Sydney Olympic Park New High School

Architectural Response to SDRP Report

Authority: State Design Review Panel

Sheet title
SSDA
Proposed Ground Plan

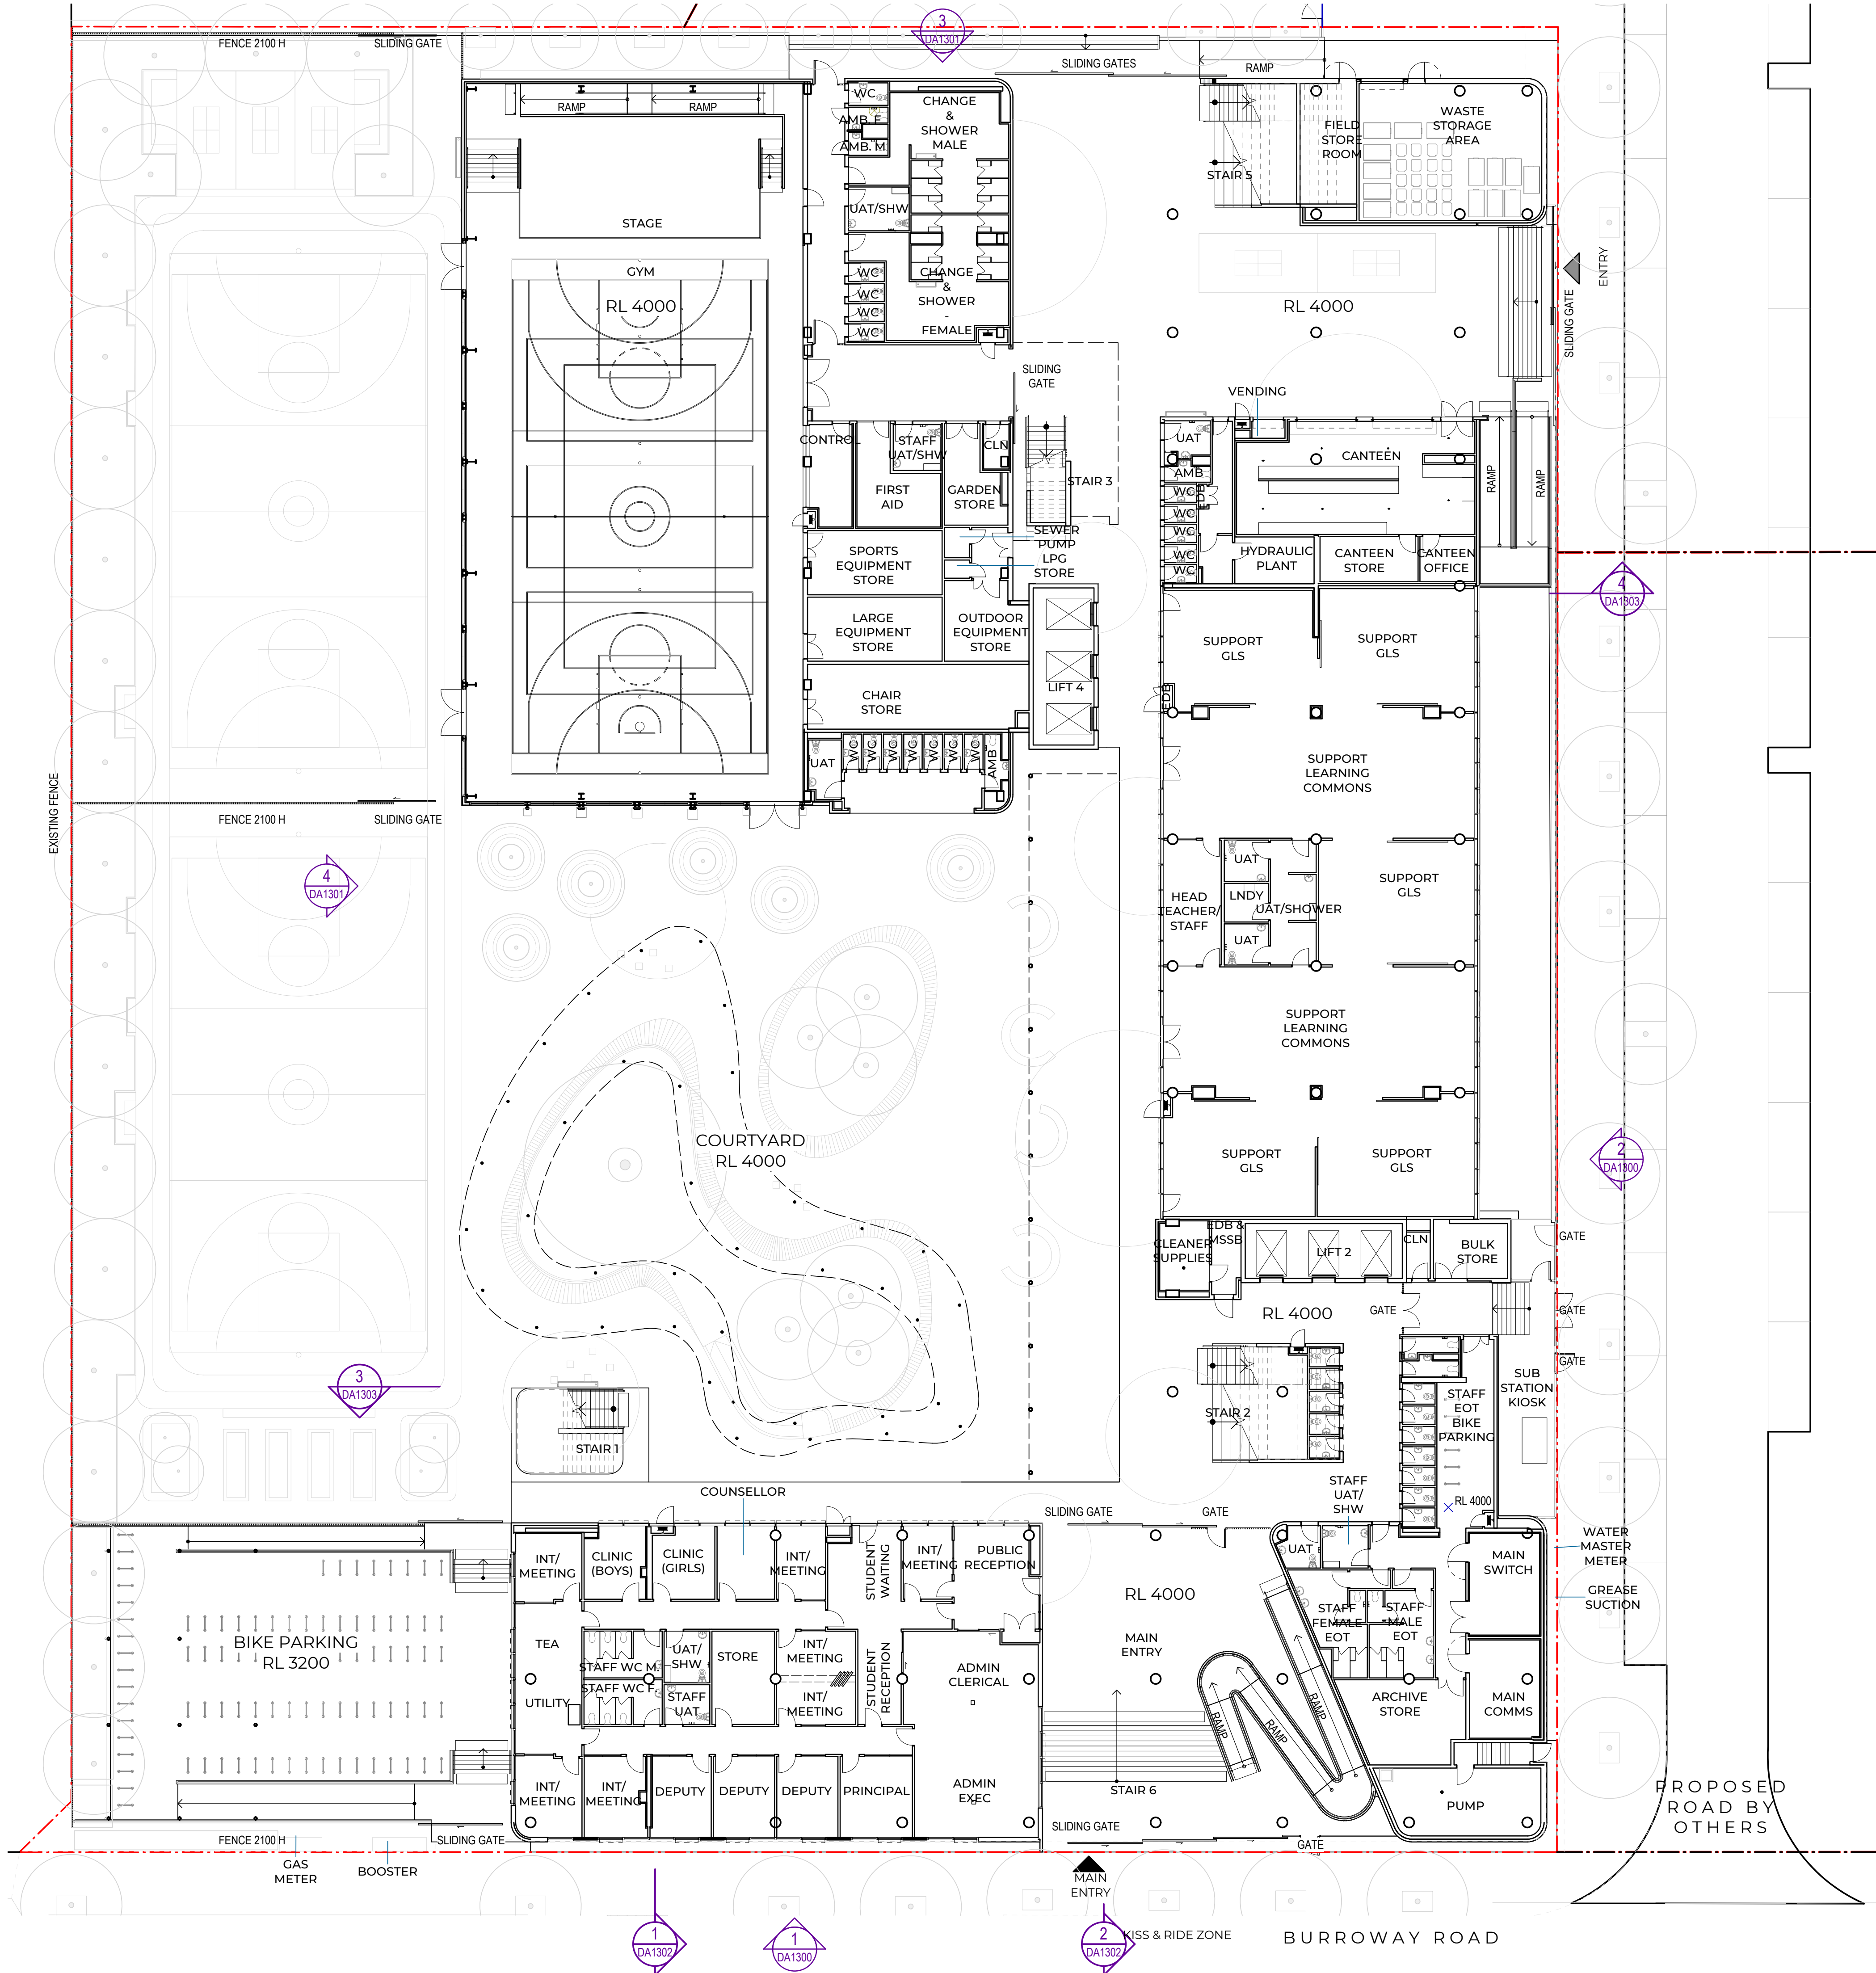
Comment: Undercroft entry – Illustrate this area in greater detail to demonstrate how the height and width constraints have been mitigated through lighting, materiality, surface treatments and other strategies.

The school's main entry from Burroway Rd (the undercroft entry) has been reconfigured by widening the opening into the school courtyard. Previously, the opening on the northern side of the undercroft was 5.86m in width; this opening is 13.35m in width. This increase ensures that the entrance will be capable of managing the volume of students that move through the space as they arrive at and depart from the school. It dramatically enhances a sense of welcome and openness from Burroway Rd, bringing substantially more daylight in from a northern aspect. It also provides new glimpses of the staircase rising up to level one.

The arrangement of the stair and ramp in the undercroft has been simplified to improve the flow of students through the undercroft. The ramp is now located on the eastern edge of the space, taking up a more compact footprint than previously. A wide stair inhabits the western side of the undercroft, creating a generous, axial thoroughfare that is at minimum 9m in width.
